Householder Proforma

Application Ref: 2021/0811
Address: 7 Stanhope Gardens, Old Town, Barnsley, S75 2QB
Neighbour Representations: No
Consultations None
Property Description: The semi-detached red brick built property is located in a predominantly residential area characterised by similar residential properties. The site falls south to north resulting in a small under-build at the rear elevation and benefits from a small single storey rear extension off shoot on the rear elevation. The attached neighbouring dwelling has been extended to the side and rear, adjacent to the party boundary.
Proposed Extension: Erection of a single storey rear extension with provision of associated external access steps to dwelling
UDP Designation: Housing Policy Area
Local Plan Designation: Urban Fabric
Conservation Area: No
Relevant History: N/A
Acceptable in Principle: Yes

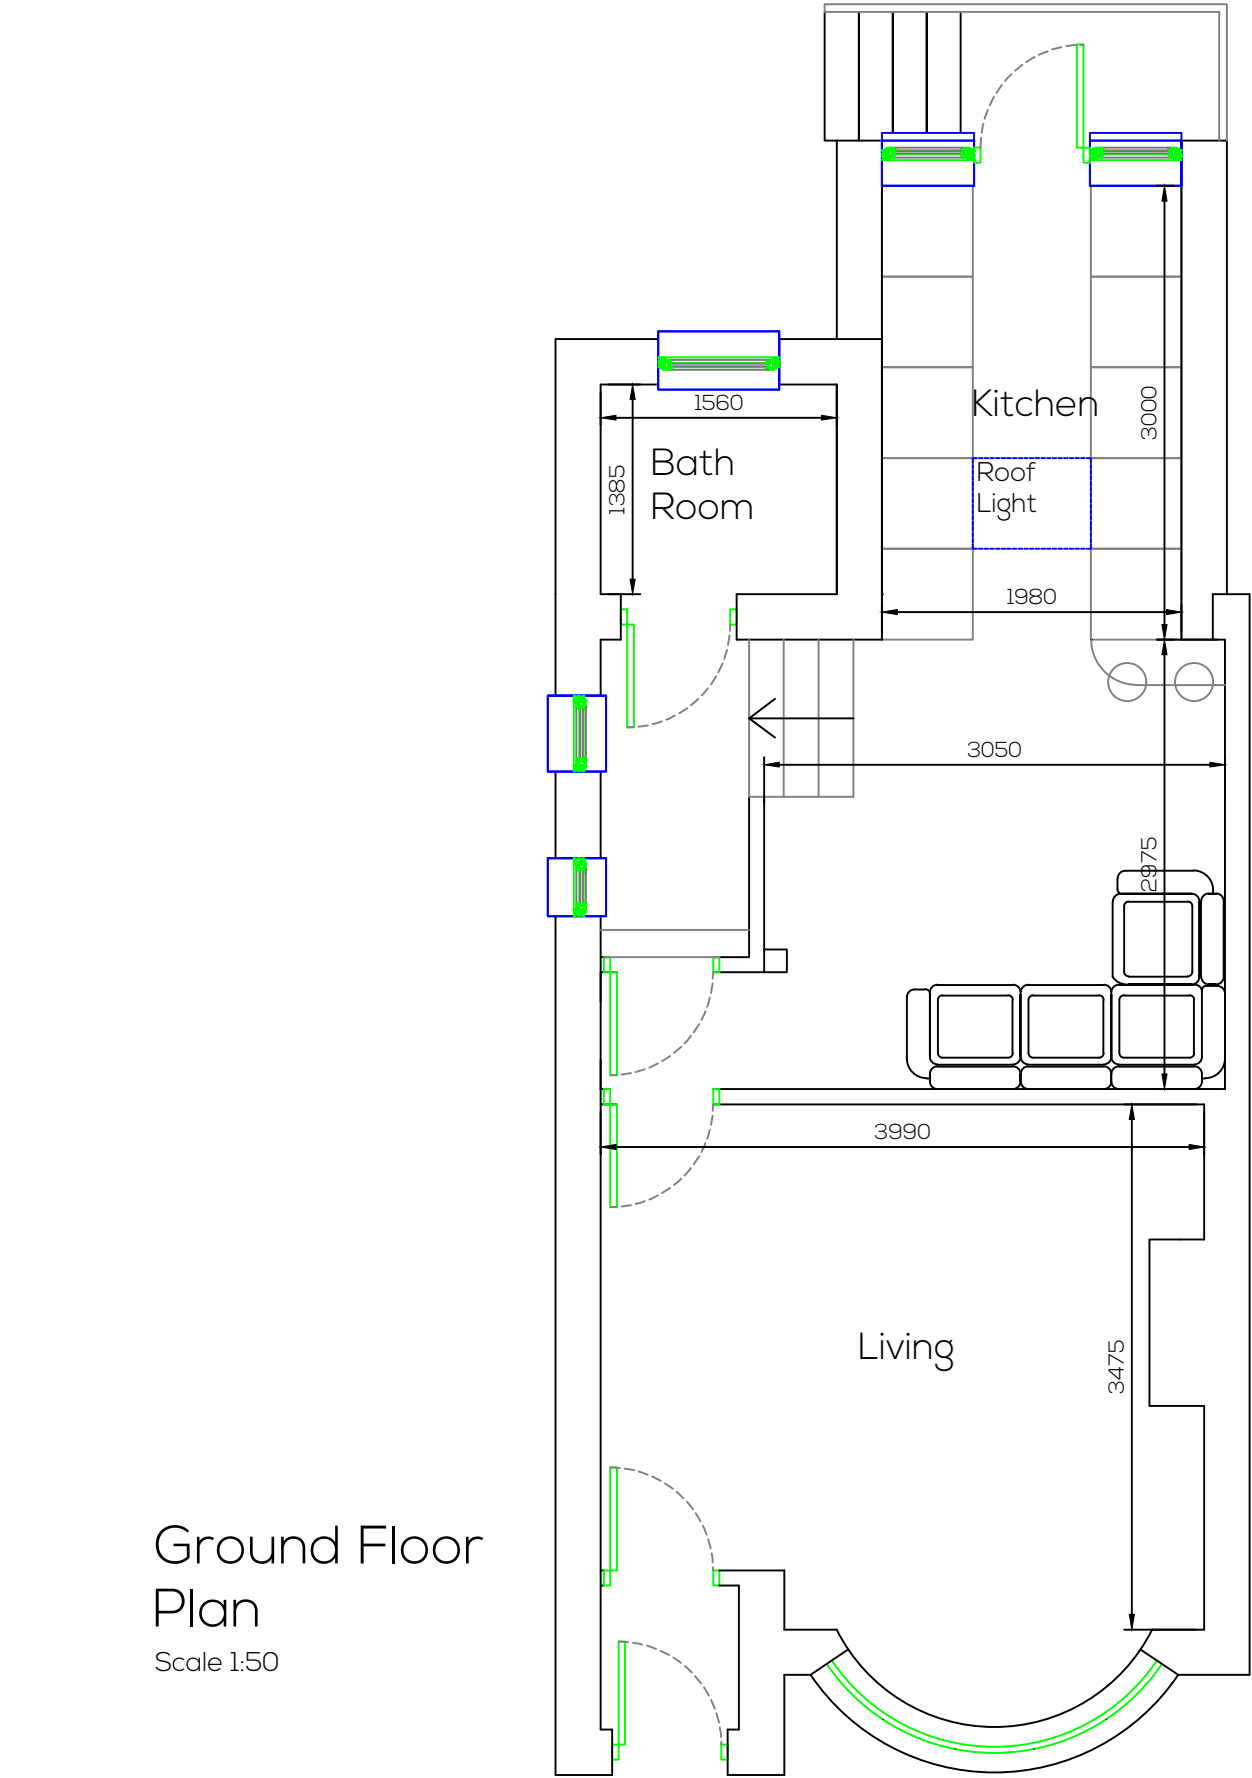
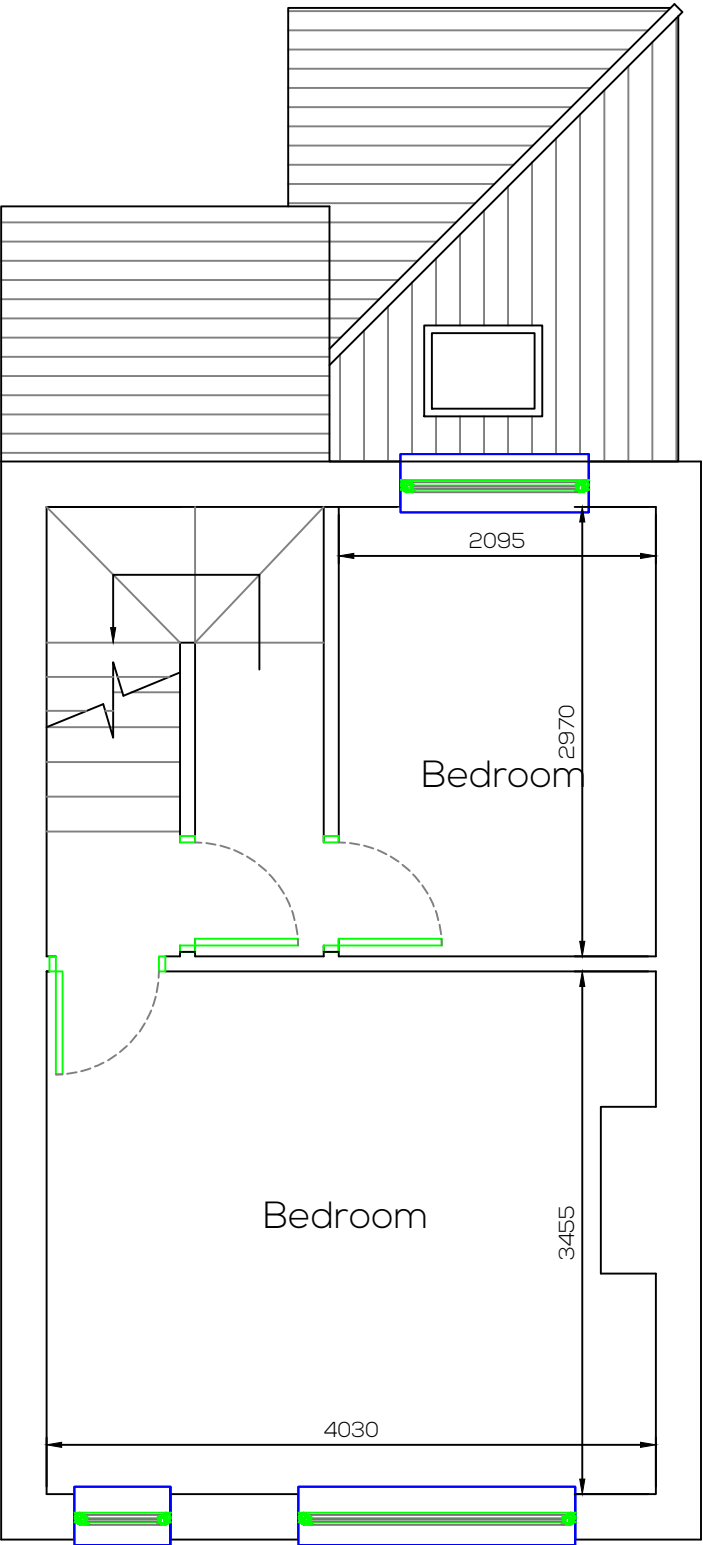
Yes / No (include comment if required)
Single Storey	
1. terraced property and less than 3.5m (projection to rear)?	
2. semi-detached and less than 4m?	Yes; 3m projection
3. if more than 3m are the eaves more than 2.5m in height?	Yes: 3.2m would not result in a significant increase in overshadowing of neighbour due to rear extension at the neighbouring property.
Two Storey	
4. terraced property and less than 2.5m (projection to the rear)?	
5. semi-detached and less than 3.5m?

The proposal does include a raised platform, which provides access to the rear garden, however it does not provide enough space to incorporate a table and chairs which would limit any opportunity for overlooking of the neighbouring gardens and as such is acceptable.

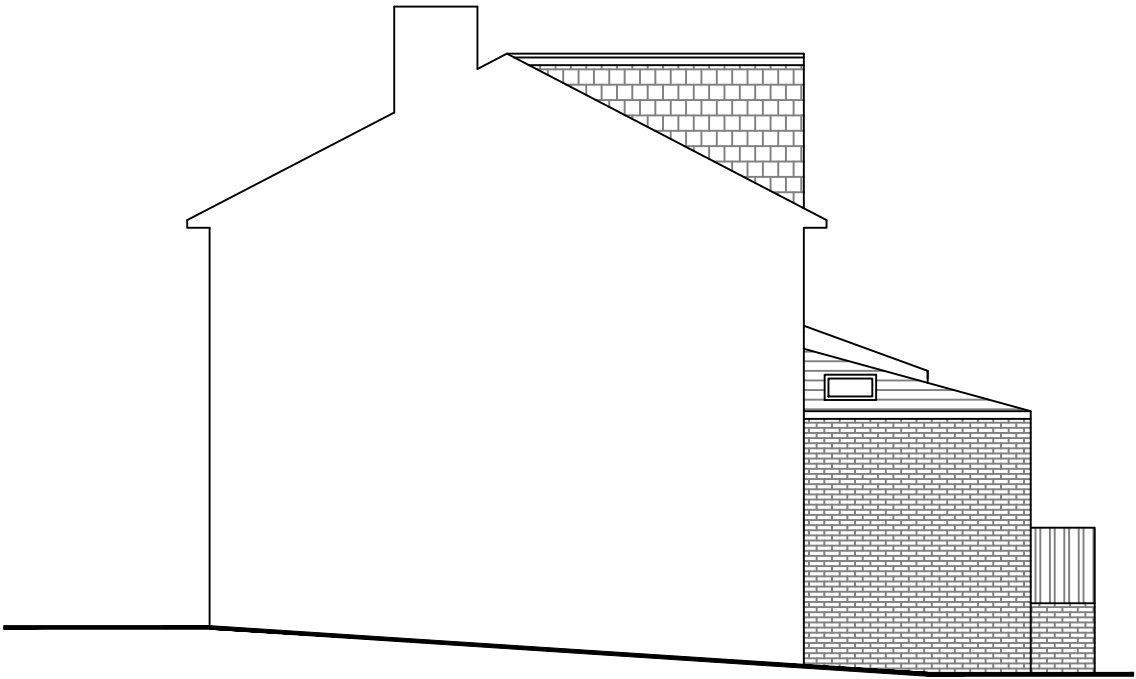
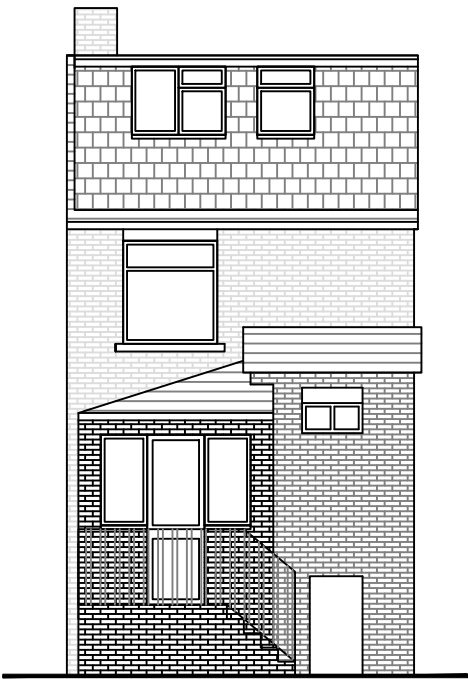
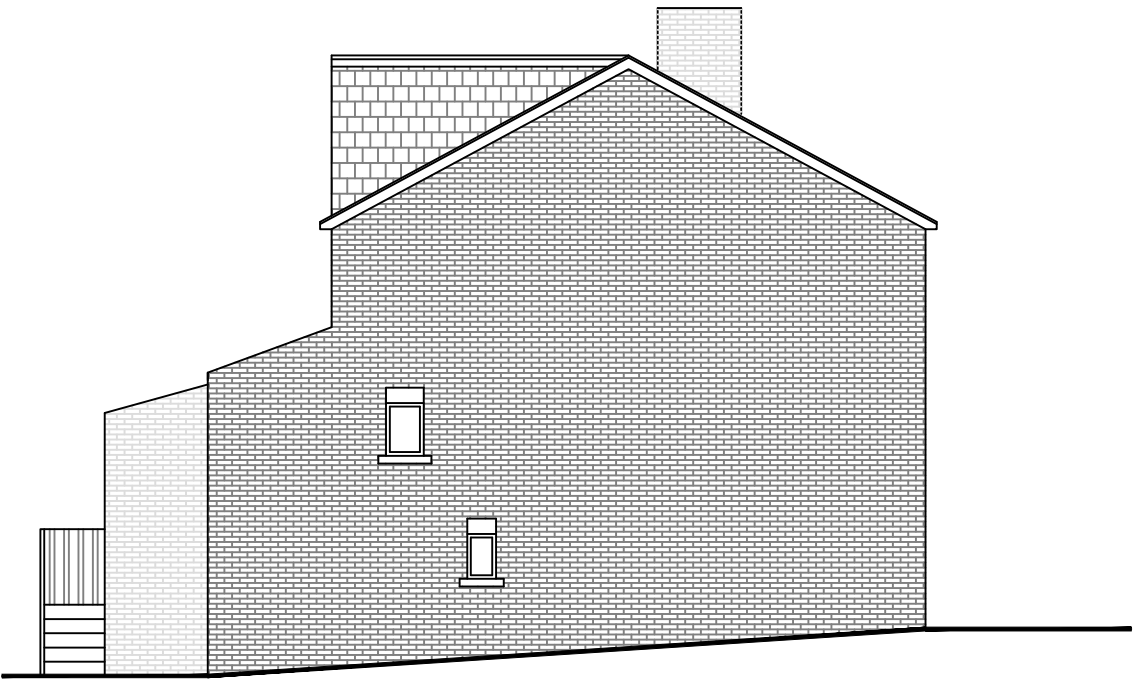
All	
6. materials to match	Yes; brickwork to match
7. roof design compliments / ties in well	Yes
8. habitable room windows on the side elevation?	No
9. distance to rear boundary (shared with another residential property) 10m or more?	Single storey; the extension is to located a sufficient distance (approx 9m) for the existing boundary treatment to provide adequate screening to limit overlooking

Recommendation: Approve with Conditions
